FW: GAA 21028 - Manor Court, High Street, Harmondsworth, UB7 0NL

27256/APP/2021/3759 MANOR COURT Details of Landscaping in compliance with
HIGH STREET condition 6

PLANTING PLAN 2 OF 2

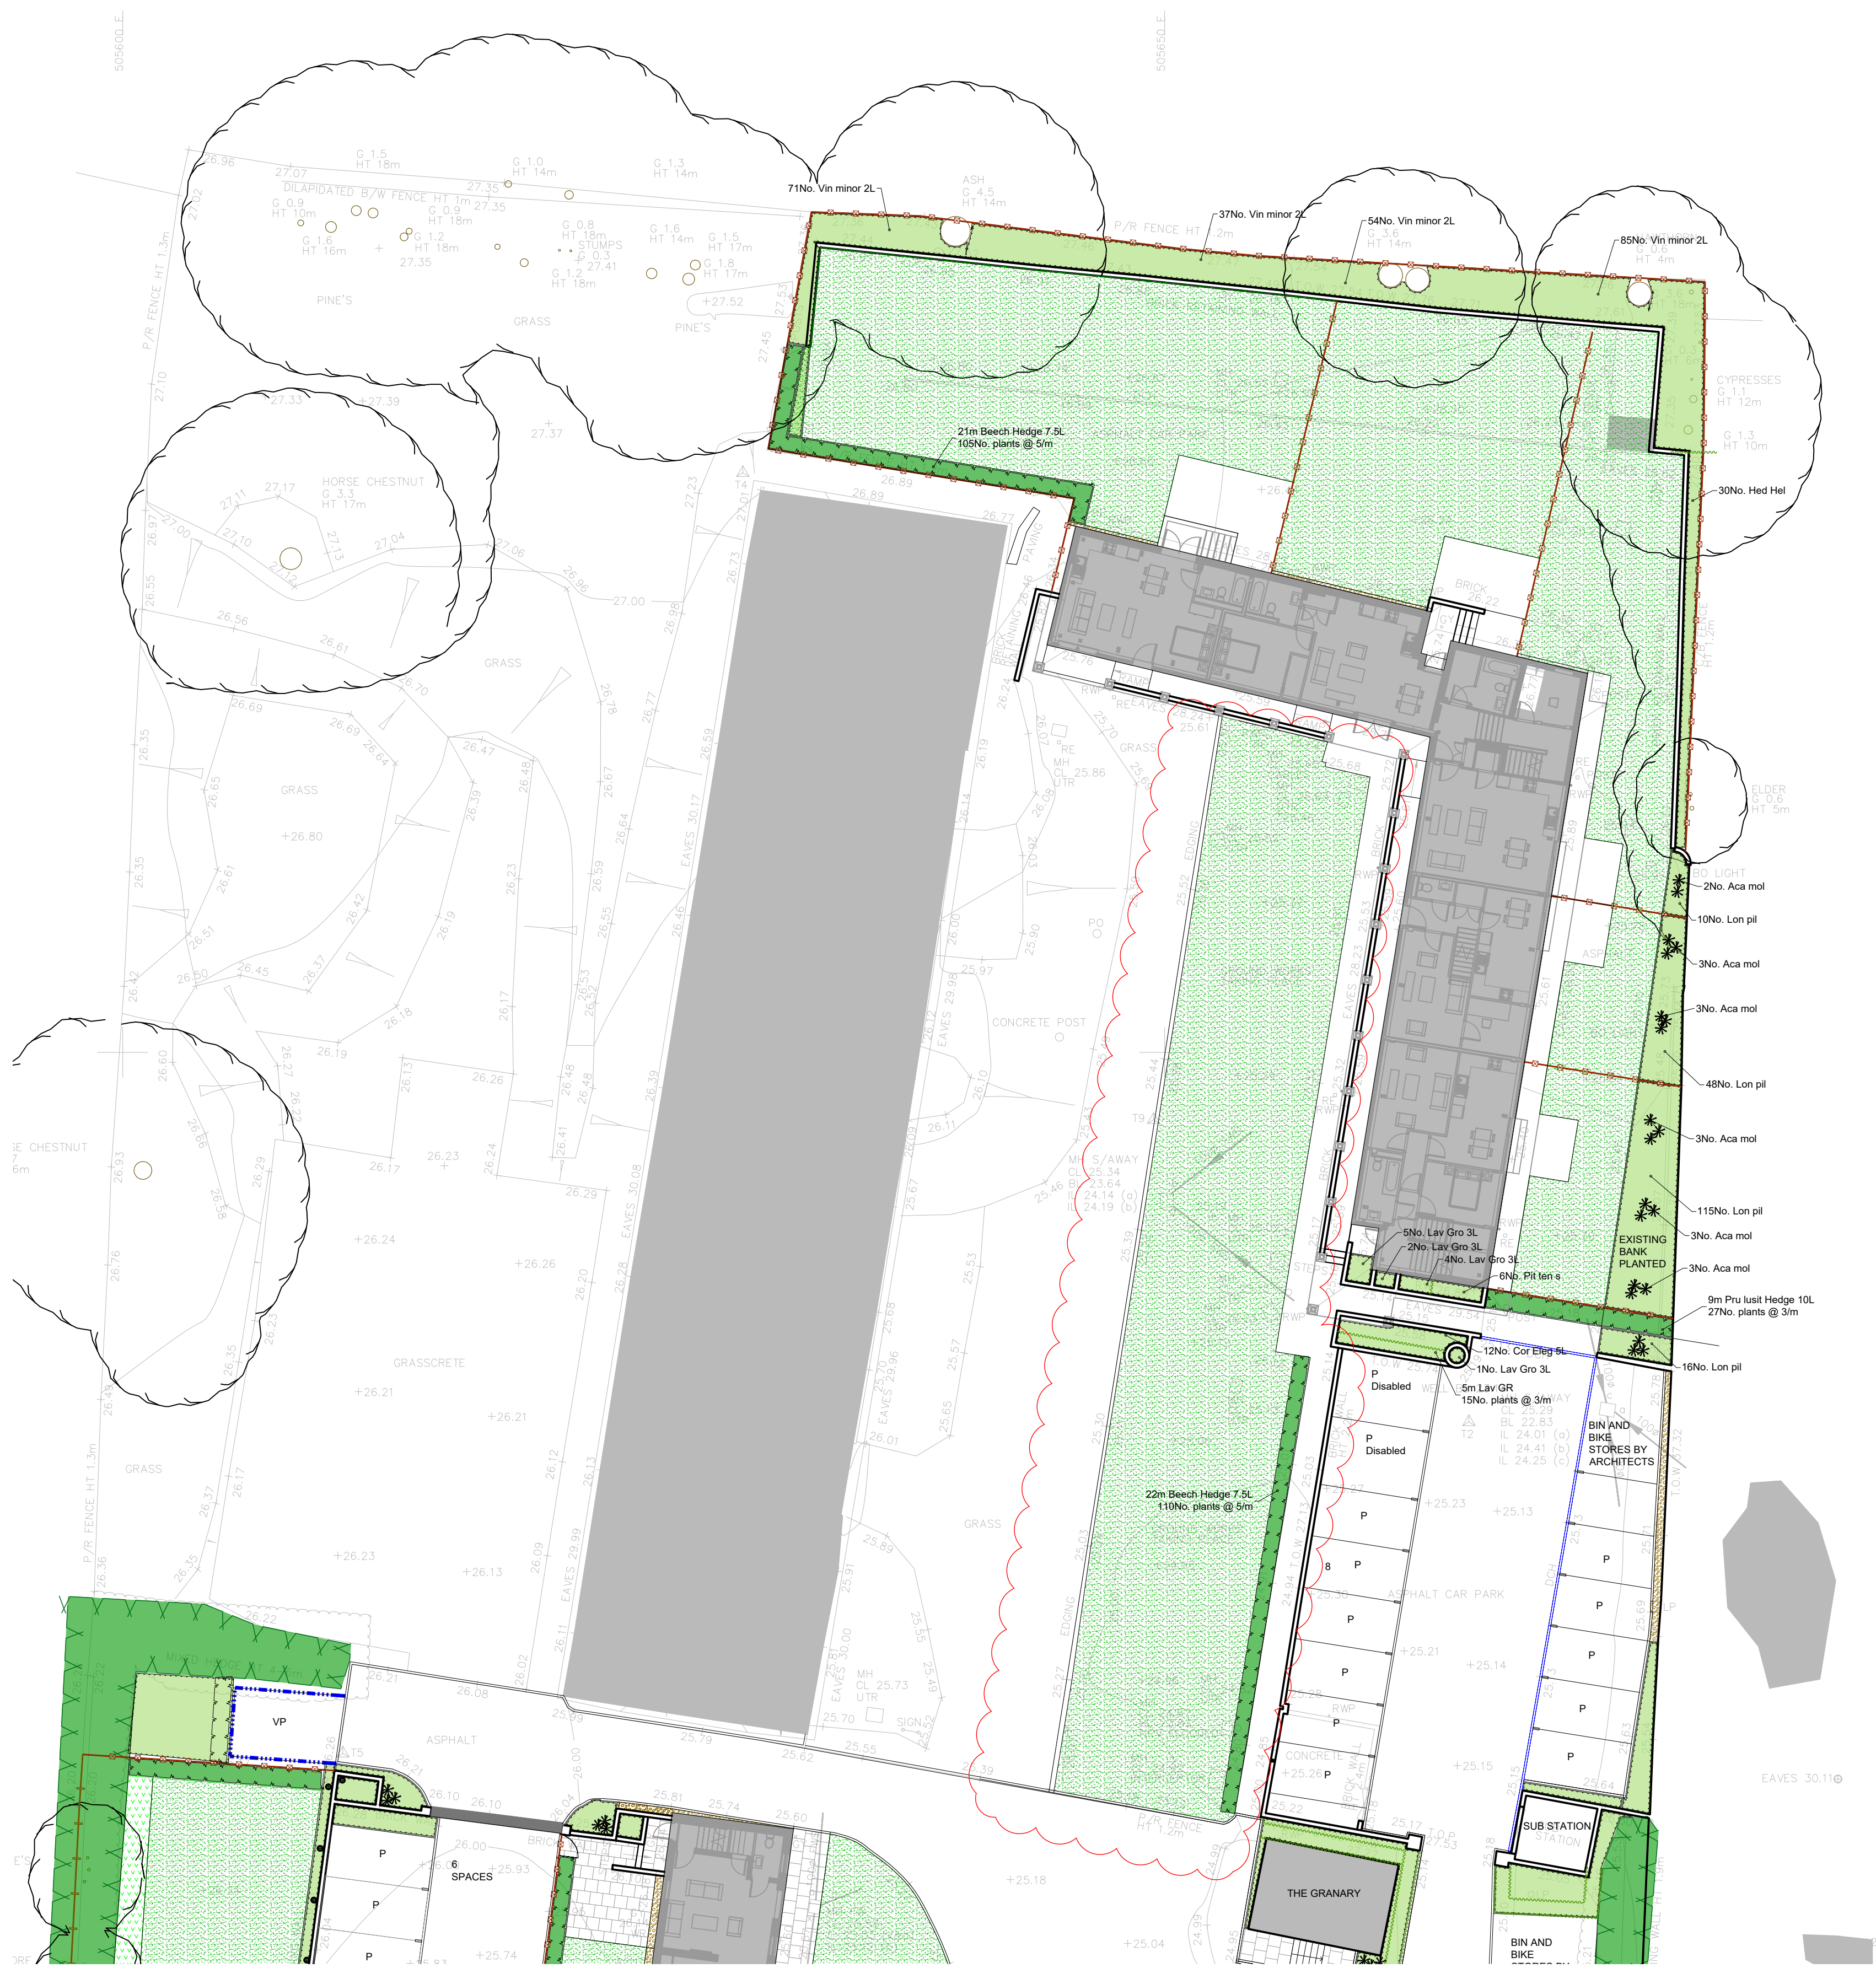
We are concerned that the Grade I listed barn is not shown on the proposed landscaping plan.

However, a Beech hedge is proposed to be planted directly against the footings of the barn physically blocking access to the 3 pairs of entrance doors and visually obscuring the barn. A row of 6 trees are also proposed along the length of the barn. The hedge and trees would be incongruous features for what was historically an open farmyard setting, which remains appreciable, and harm the significance of the barn.

Vegetation in such close proximity to a medieval barn could lead to problems with root penetration, subsidence, overshadowing and leaf litter fall which could lead to the physical decay of the structure and make adequate maintenance more difficult to achieve.

Existing structure planting (trees and hedges) is indicated on plan but should be labelled for the sake of clarity.

1. The post and rail fence helps to divide ownership between private and public. It defines the garden space. It is a natural structure (Which is found onsite). The post and rail fence is to be a traditional chestnut fence with morticed joints. It also allows a degree of permeability.

2. Trees and hedges are pulled some 12 m away from the face of the barn. The hedge is at a lower level, a granite sett edge divides the lawn in two. The hedge would be maintained at heights no greater than 1.2m. We have proposed a native hedge to try and increase opportunities for biodiversity. This hedge is typical of the existing landscape character.

3. Tree species – With climate change being an ever important factor, the cumulative effect of planting more trees helps to increase carbon storage. Please refer to this link by the woodland trust for further information. The trees used have tight light canopies, thus permeability through is maintained. They also bear small fruit which again improves opportunities for biodiversity.
